AFRA CONSTRUCTION, LLC
2501 YALE BLVD. SE, SUITE 102
ALBUQUERQUE, NM 87106
PHONE: 505-242-1745
FAX: 505-242-1737

November 14, 2016

Re: Project #1001695 Signal Allergy Clinic – EPC Comment Responses

CONCEPTUAL DRAINAGE PLAN

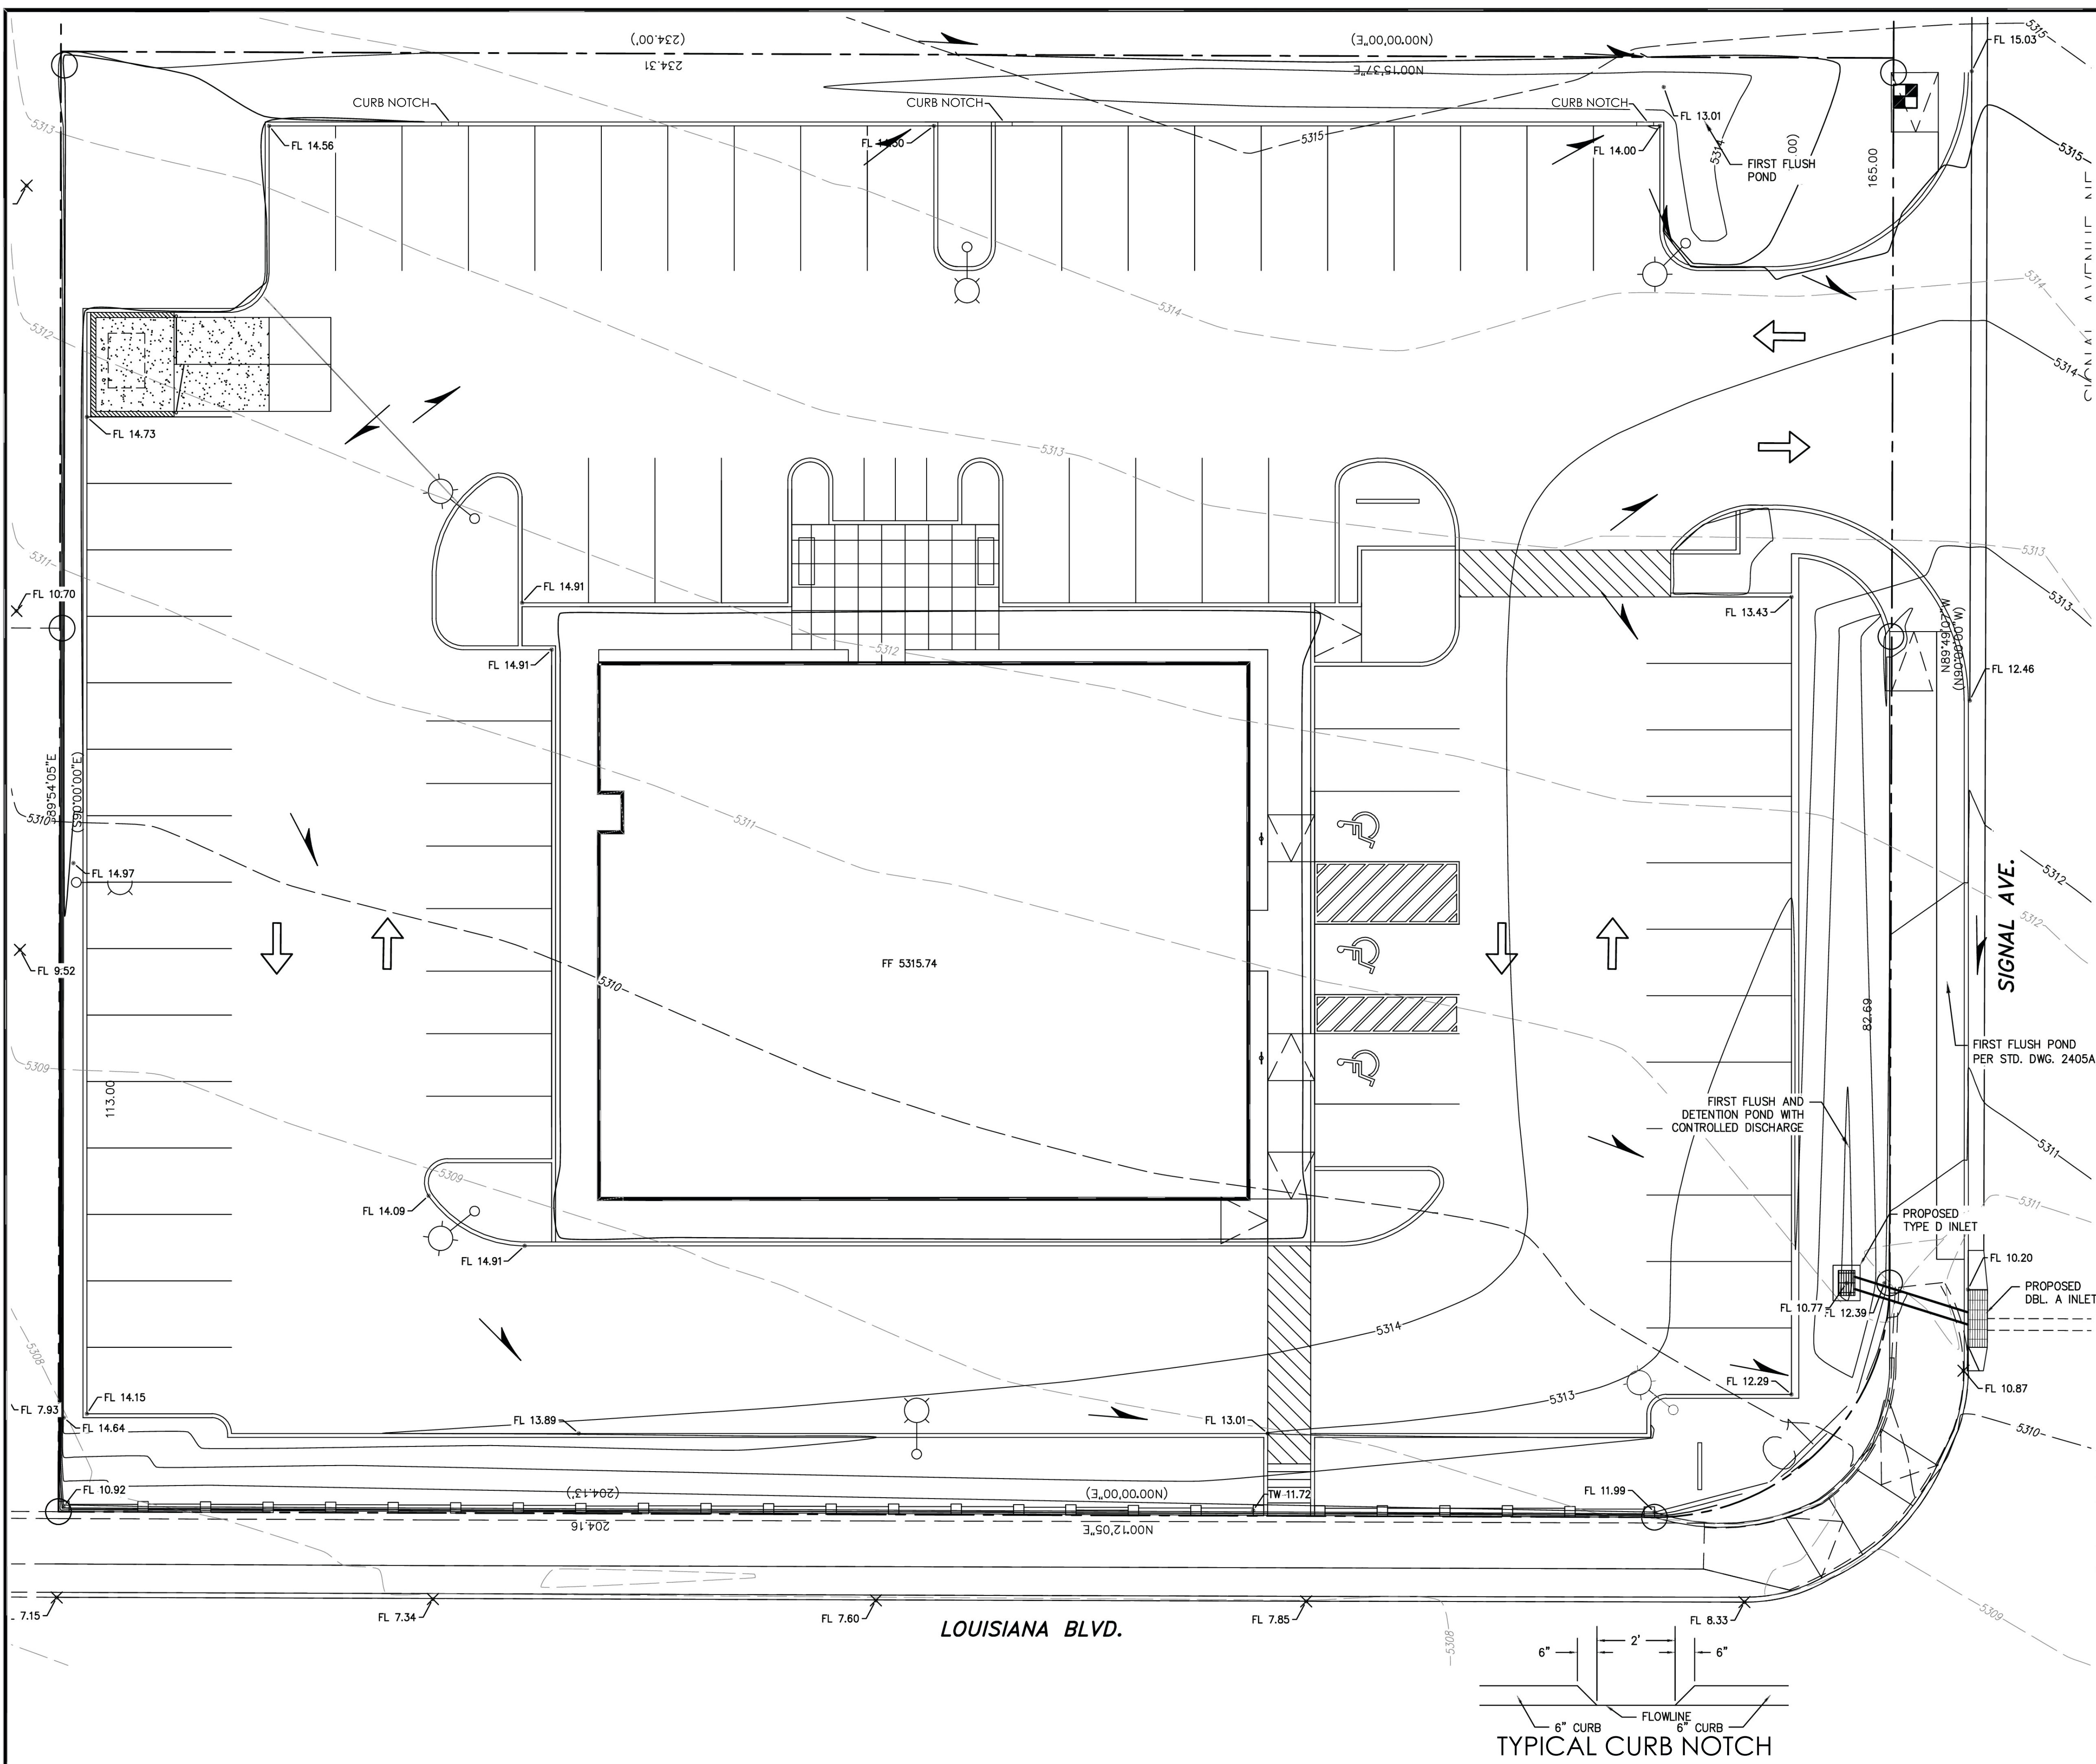
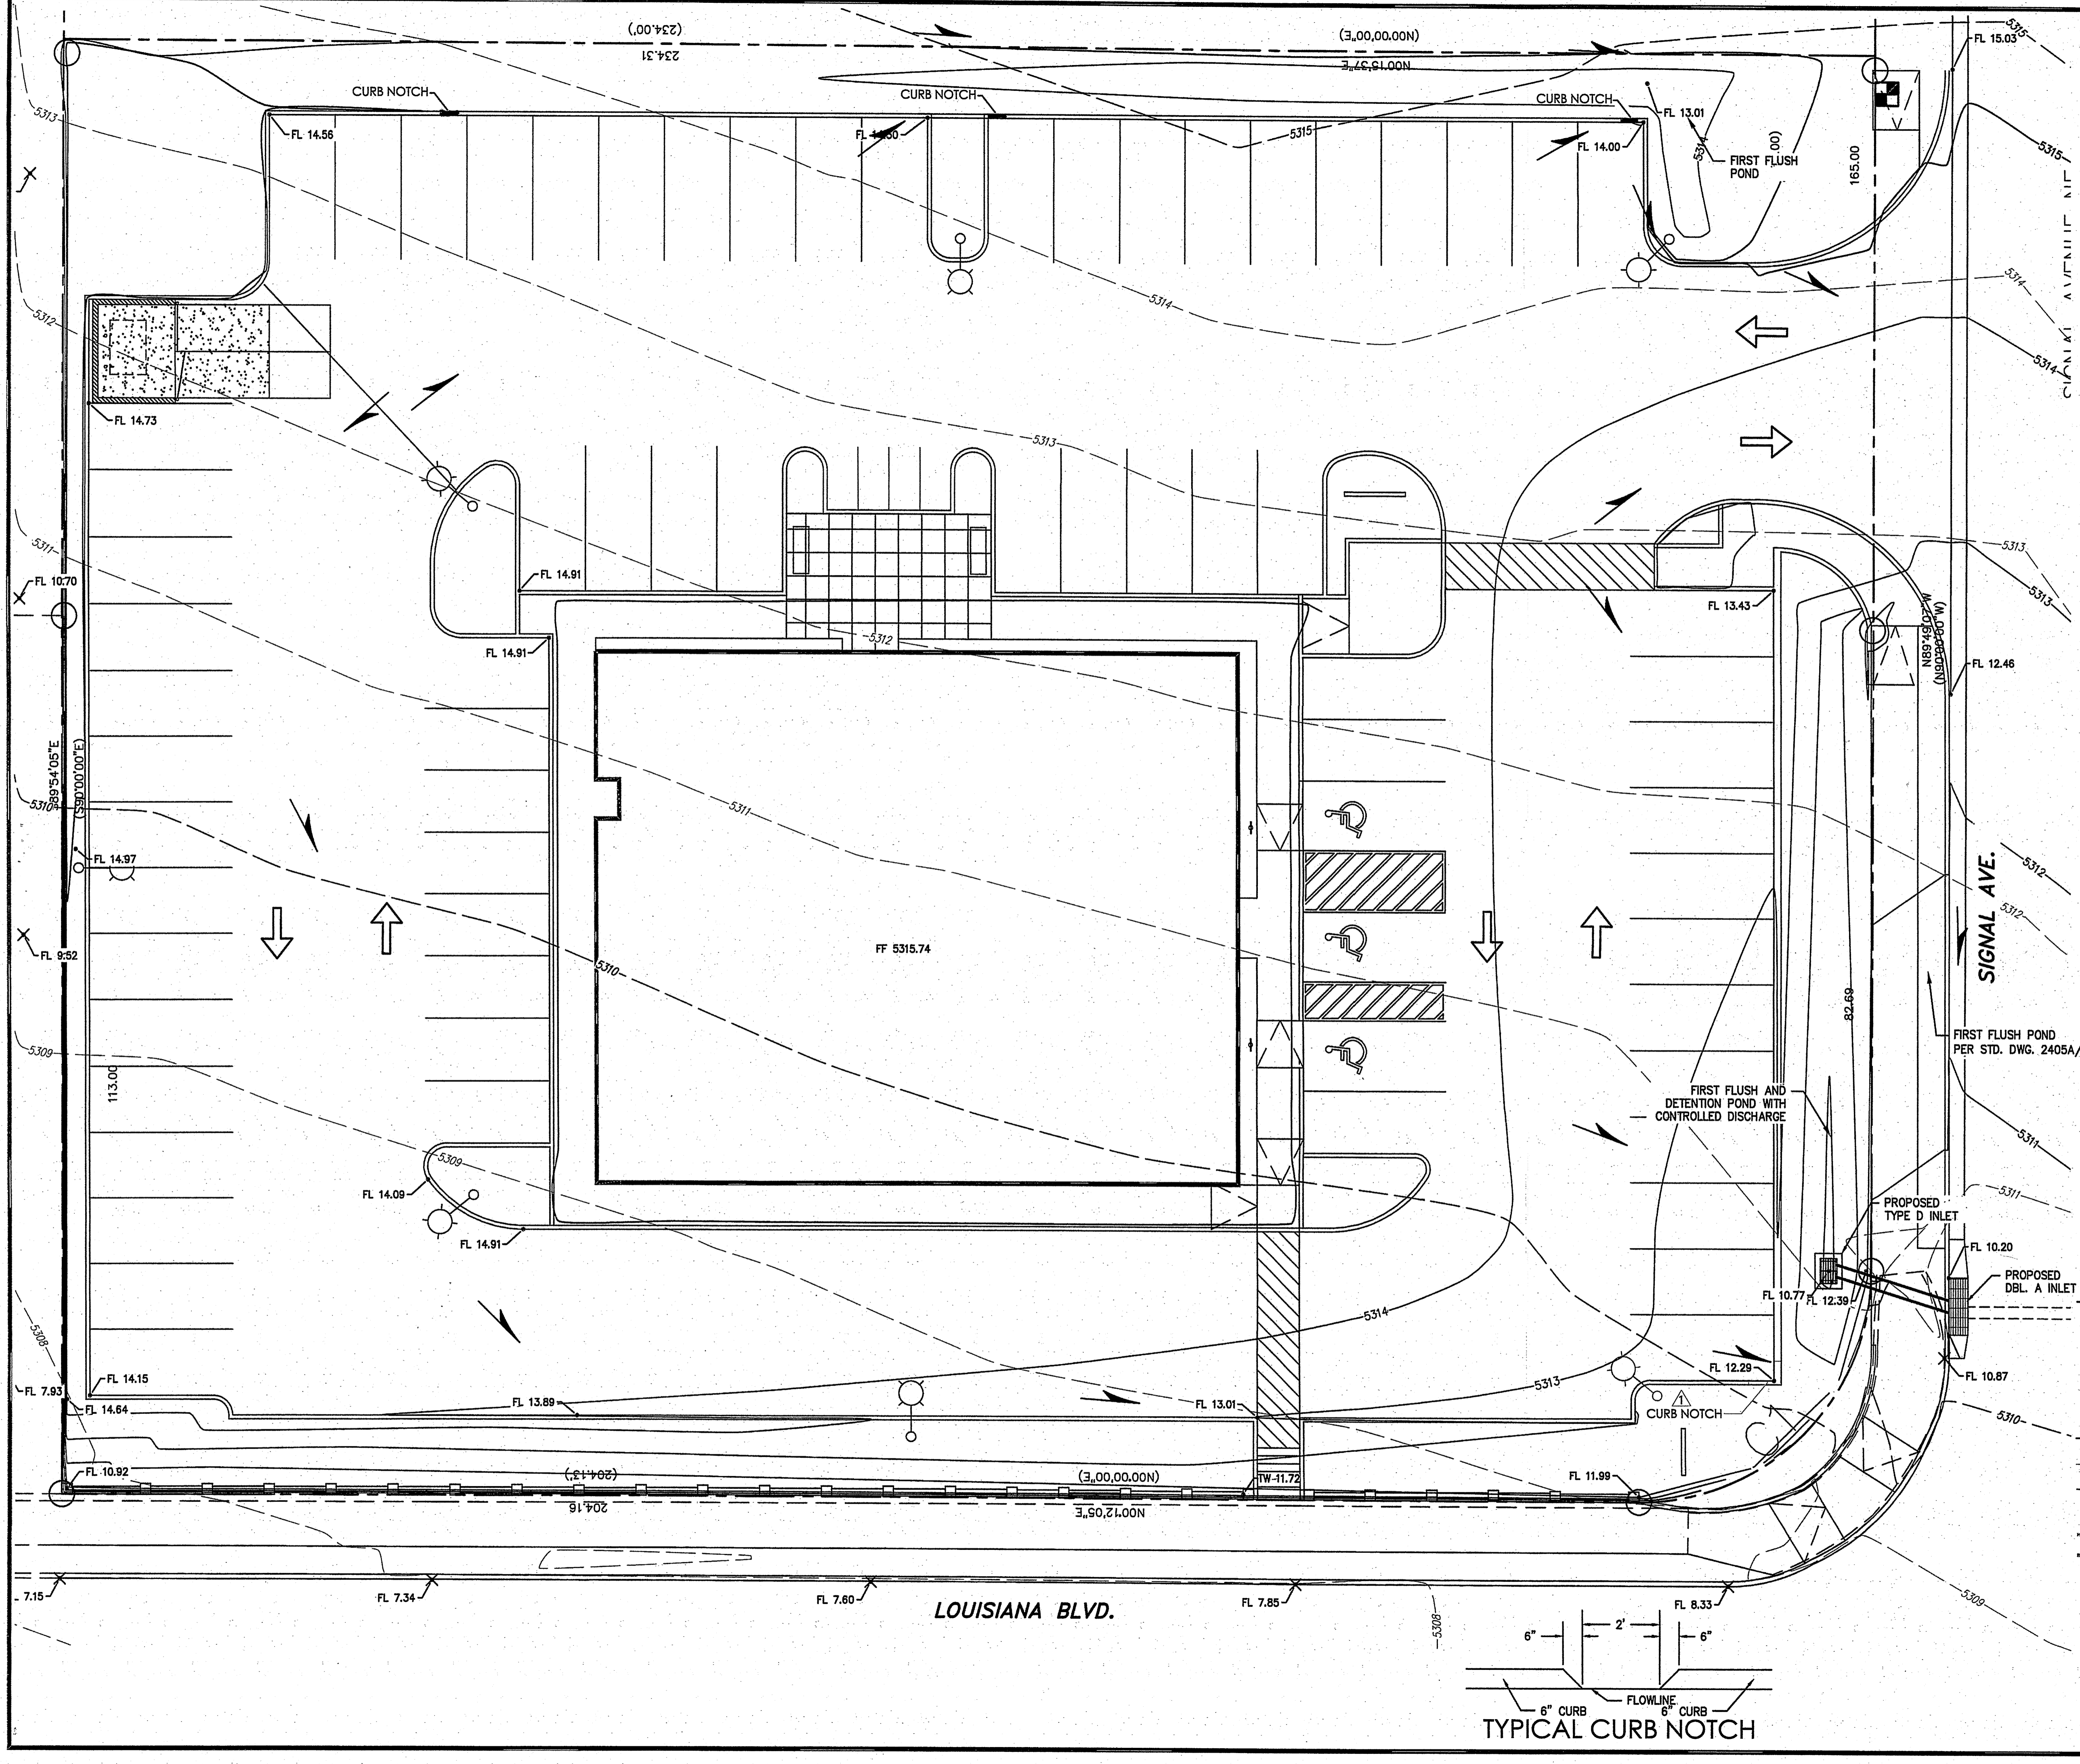
- A. Curb notches on the landscaping plan and the grading and drainage plan shall be shown in the same locations.**
 - Curb notches have been coordinated throughout each of these plans.
- B. At least a couple of curb notches shall be added to the subject site's SW corner, in the direction of water flow.**
 - Curb notches added to SW corner, see Grading and Drainage plan.
